Application No.

AB/102/11

Ground floor extension to rear of property and erection of amenity workshop to rear of garden
178 Fitzalan Road Arundel BN18 9JZ

SITE LOCATION PLAN
Scale 1:1250

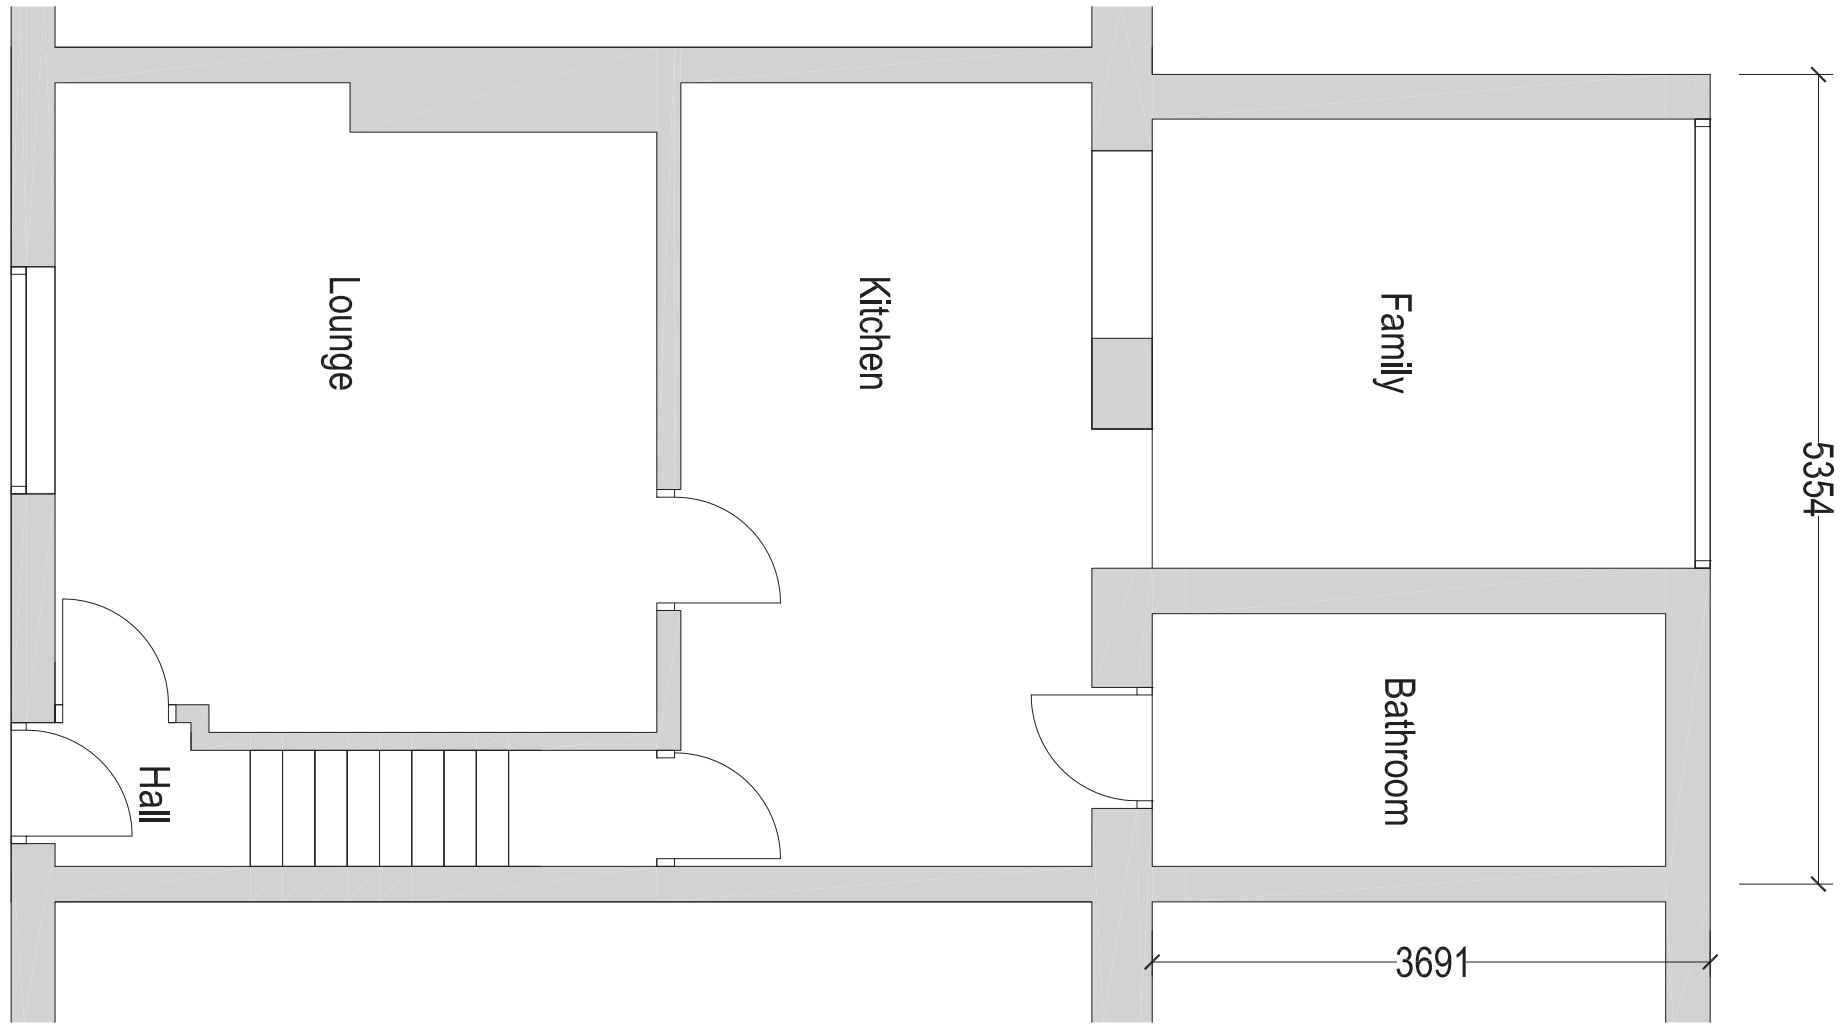
I require 1 electronic or 3 paper copies of an amended location plan edged in red

Further to your letter referenced above, please find attached electronic copies of the amended drawings you requested.

BLOCK PLAN
Scale 1:250

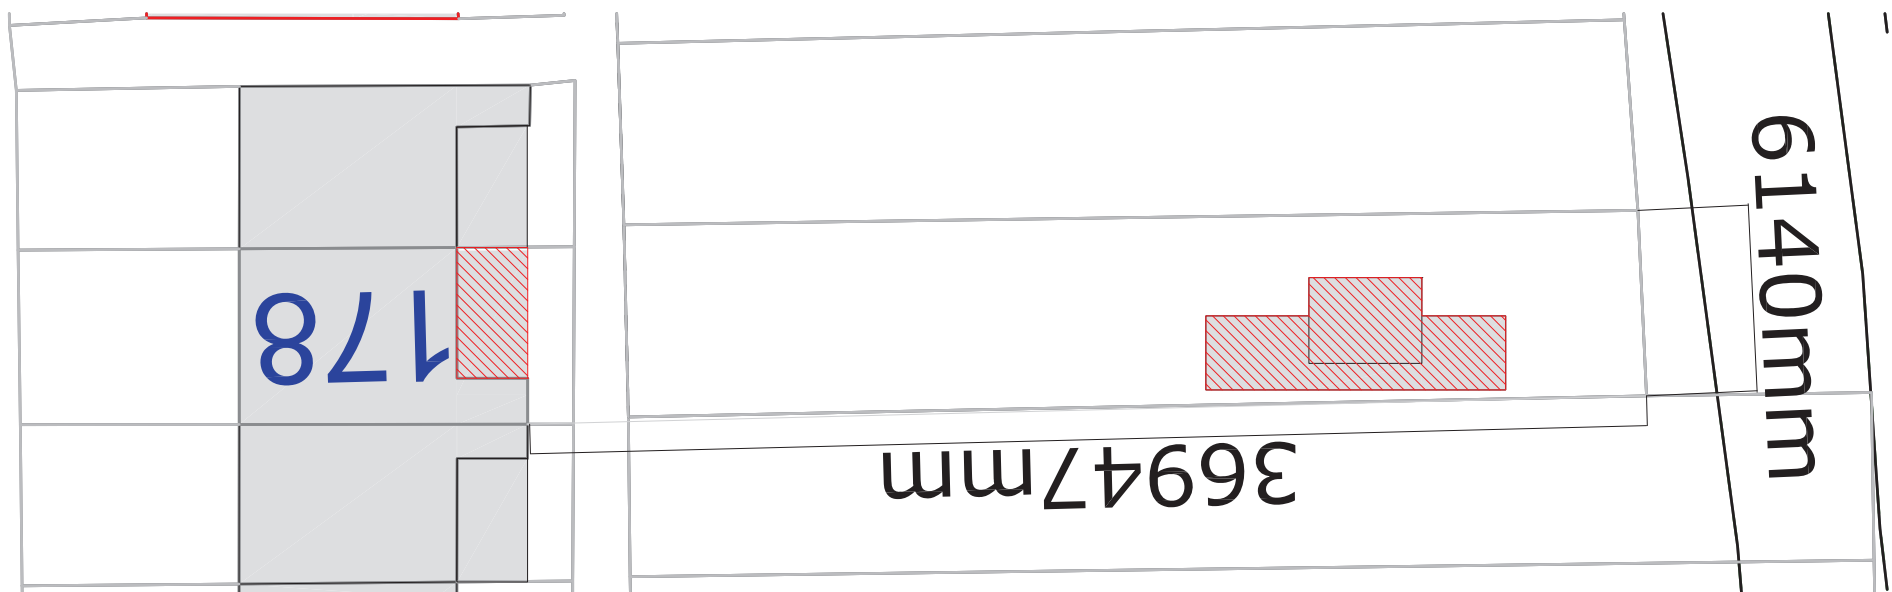
I require 1 electronic or 3 paper copies of an amended block/site plan showing the position of the proposed works only

North and South Elevations

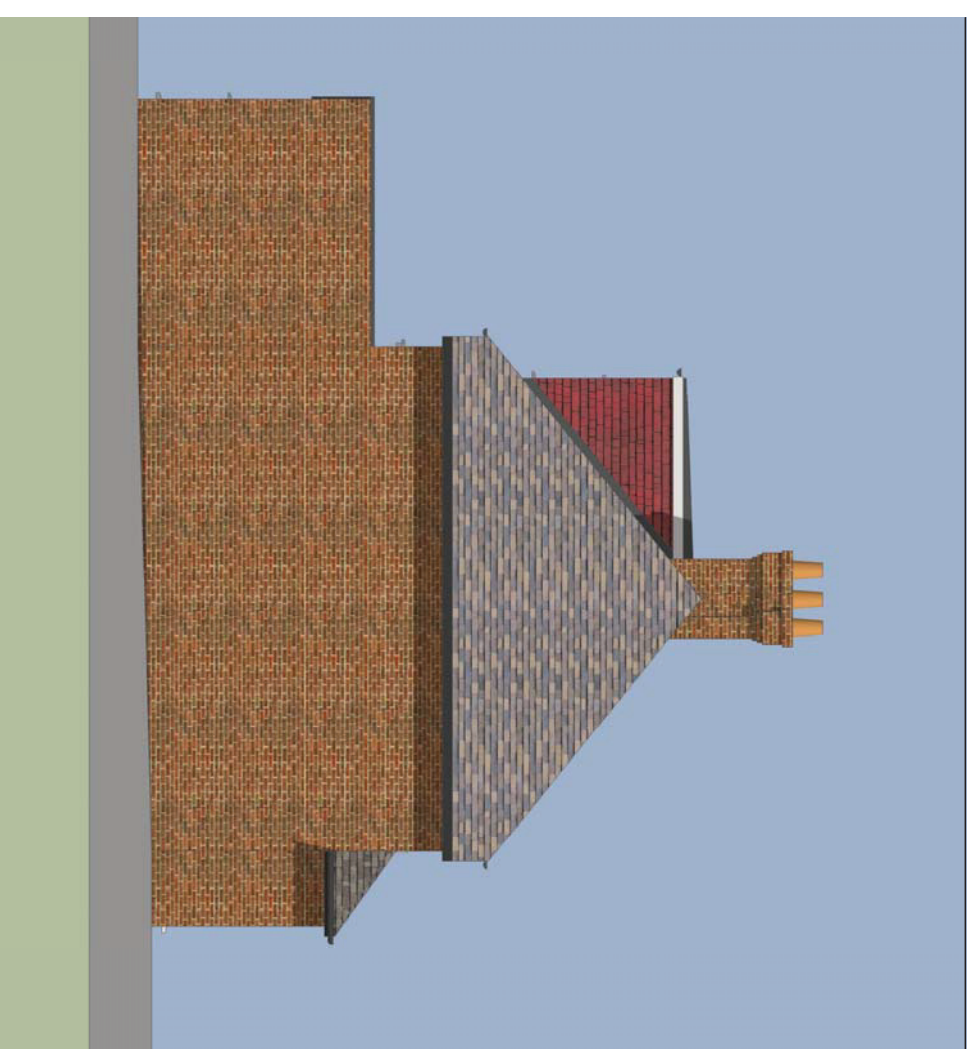
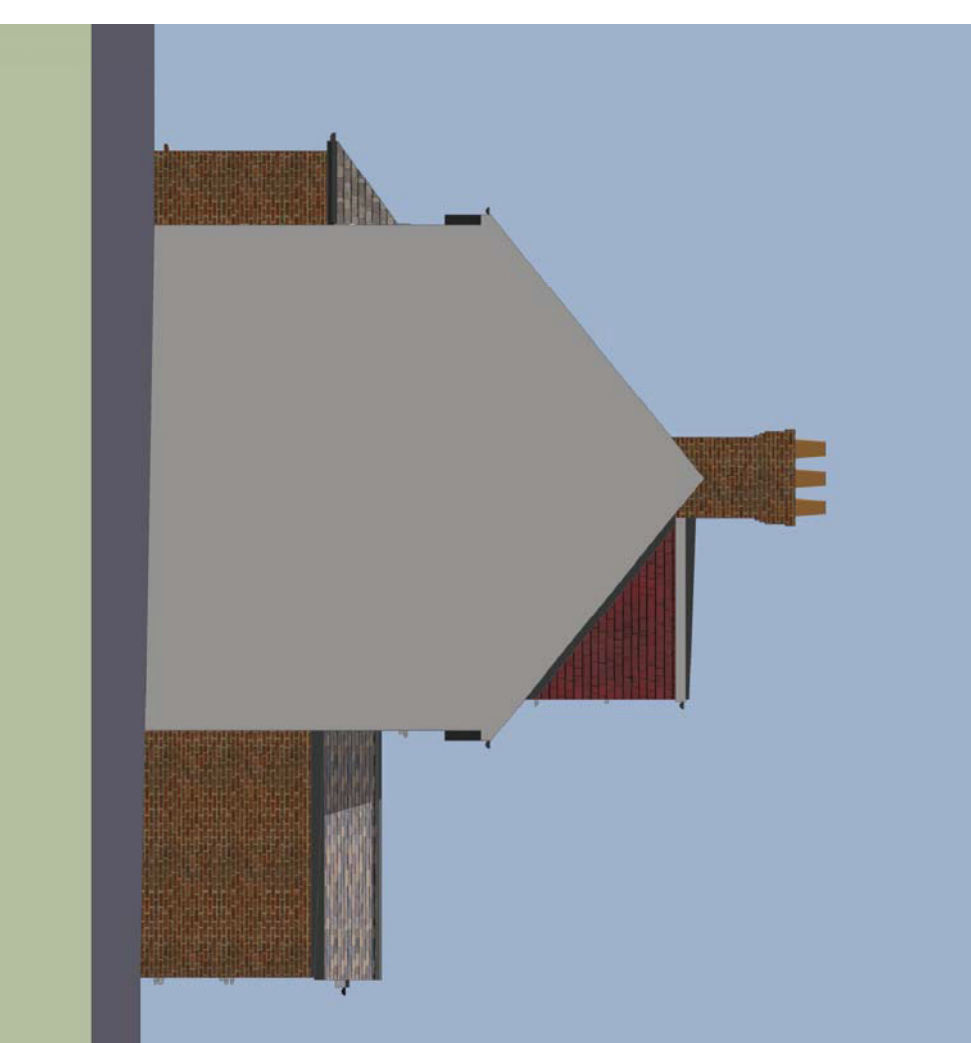
Please provide 1 electronic or 3 paper copies of existing and proposed North & South elevations accordingly
